Our Ref: FG/133/20/NMA

Non material amendment following the grant of FG/94/20/HH to change design/style of window to living room on front elevation & blocking up of windows on each side of entrance porch.

7 Little Drive Ferring BN12 5RF

DRG • 19 / 14, A. &.

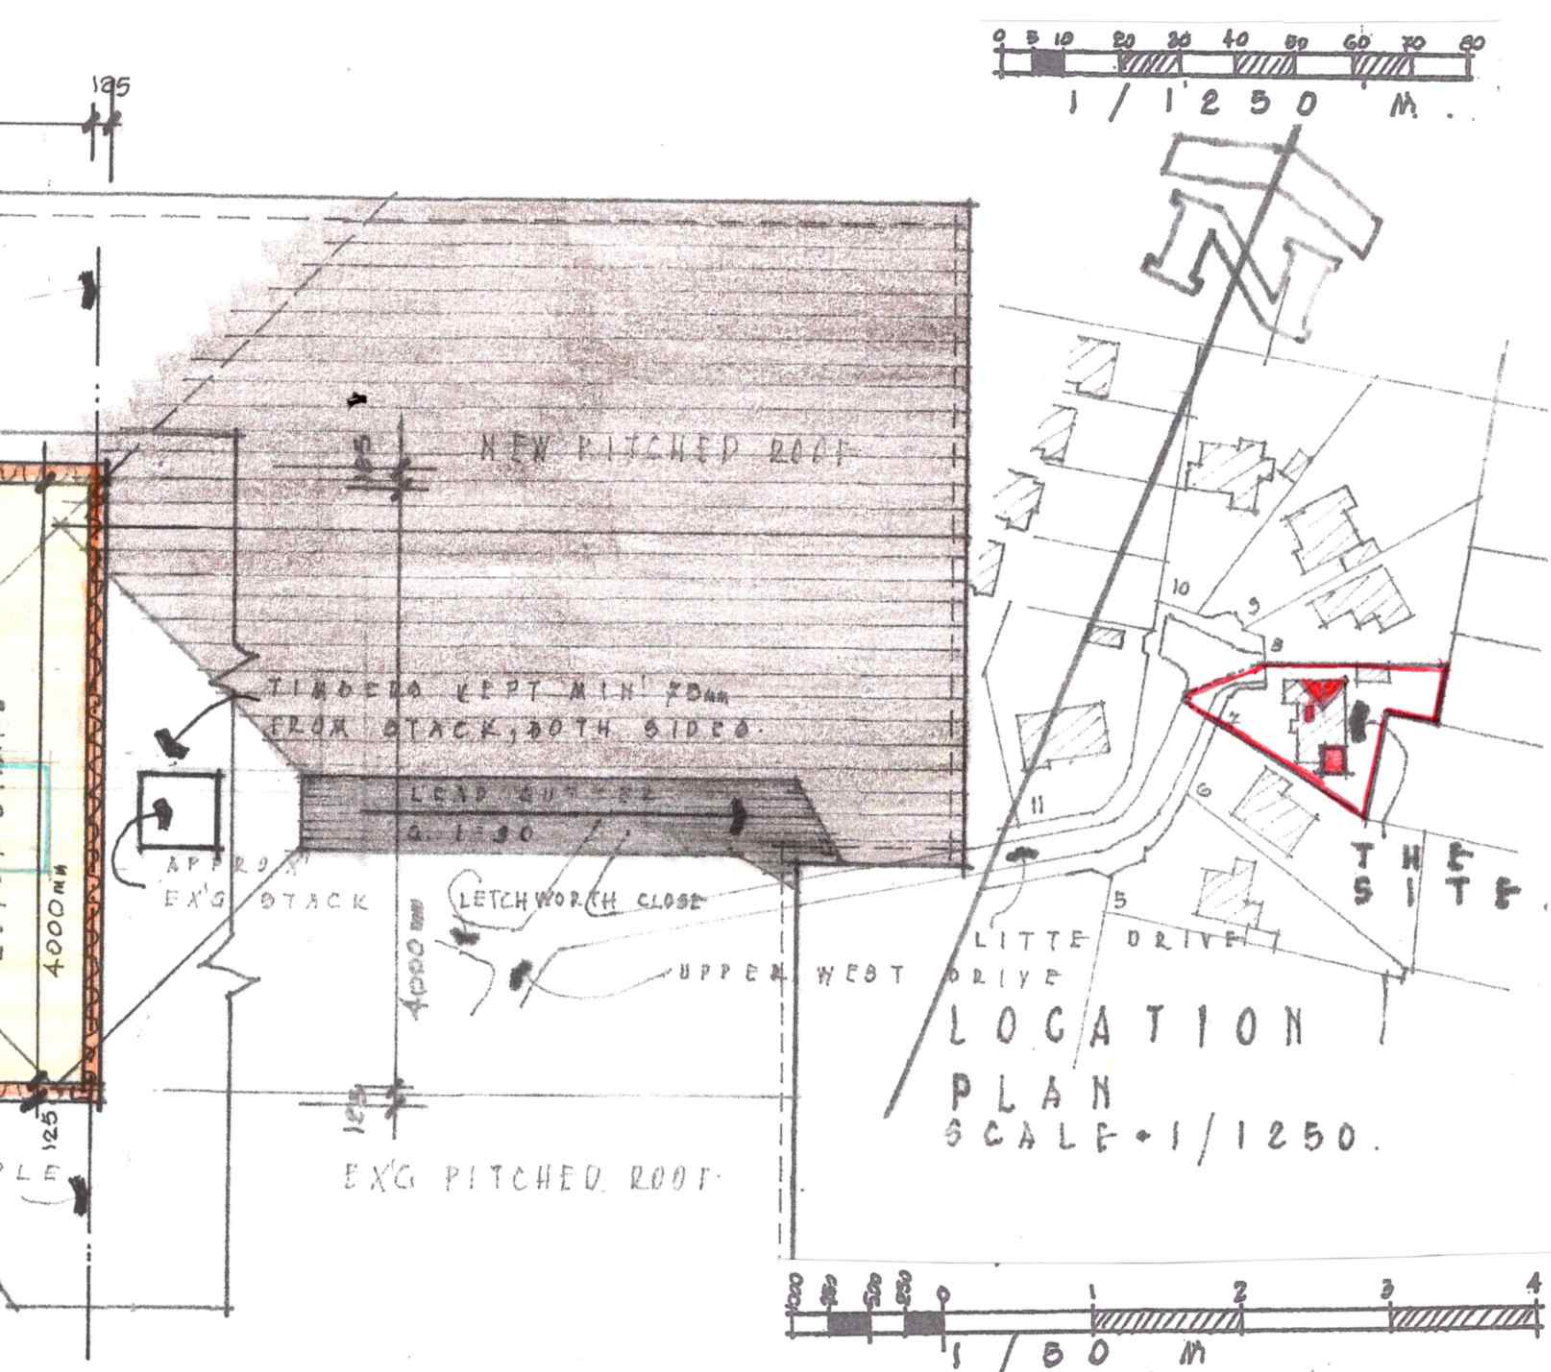
Please note that plan references 'Proposed Ground Floor Plan - 19/14/1.A - Dec 19' and 'Proposed Elevations - 19/14/3.A - Dec 2019 - (this plan is approved on the basis that the East & West elevations should be swapped and is approved on this basis)' are now replaced by 'Ground Floor Plan - 19/14/1.A.1. - Dec 2019 - Amended 22/10/2020 G.F.D' and 'Proposed Elevations - 19/14/3.A.1 - Dec. 2019 - Amended 22/10/2020 G.F.D'.
